Application No: AL/39/22/OUT
Site Address: Land to South of Dukes Road Fontwell Arundel BN18 0SP
Description of works: Outline application with some matters reserved (appearance, landscape and scale) for the erection 9 No. residential dwellings. This application is a Departure from the Development Plan.

Outline Planning Application AL/39/22/OUT

Objection to this proposal

Drawing 221528/TS/01 – Proposed Access Arrangements

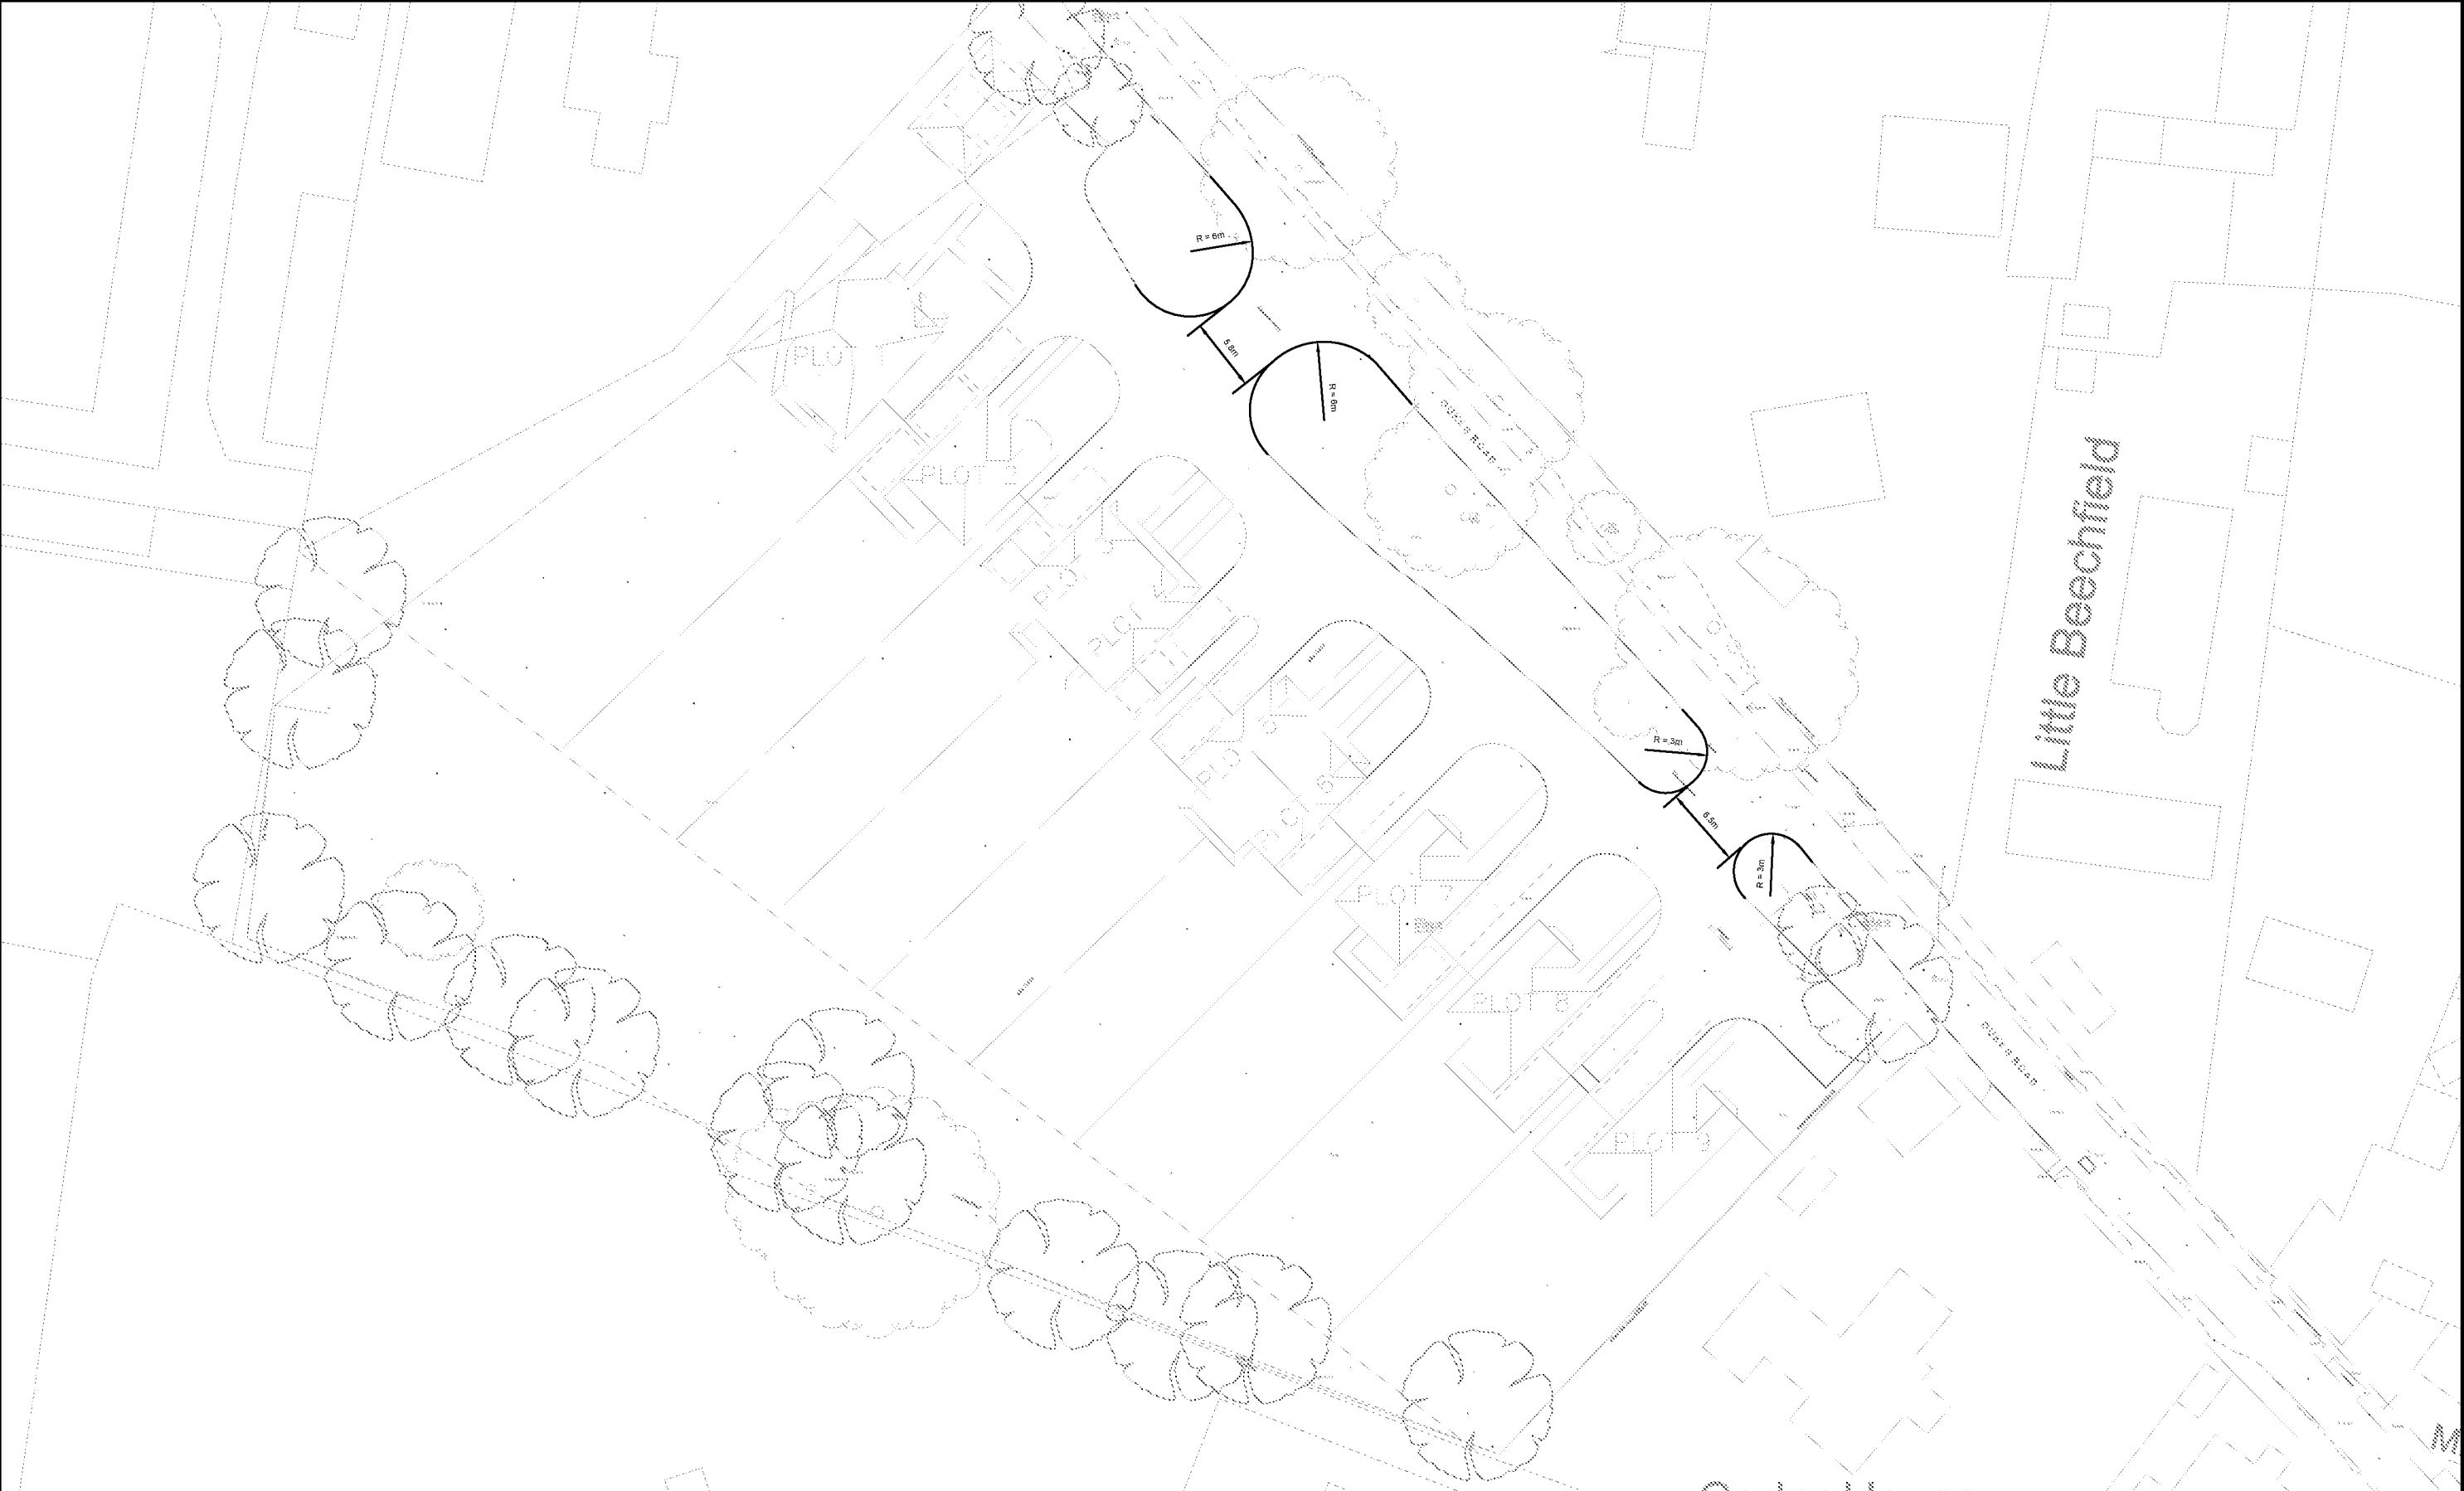
The implementation of a secondary route alongside Dukes Road with 2 entrance points to access the development would not be in keeping with the rural nature of Dukes Road and would add a level of urbanisation in such a rural area. There would be concerns about the amount of hardstanding due to the proposed access arrangement and visual impact on the surrounding rural character.
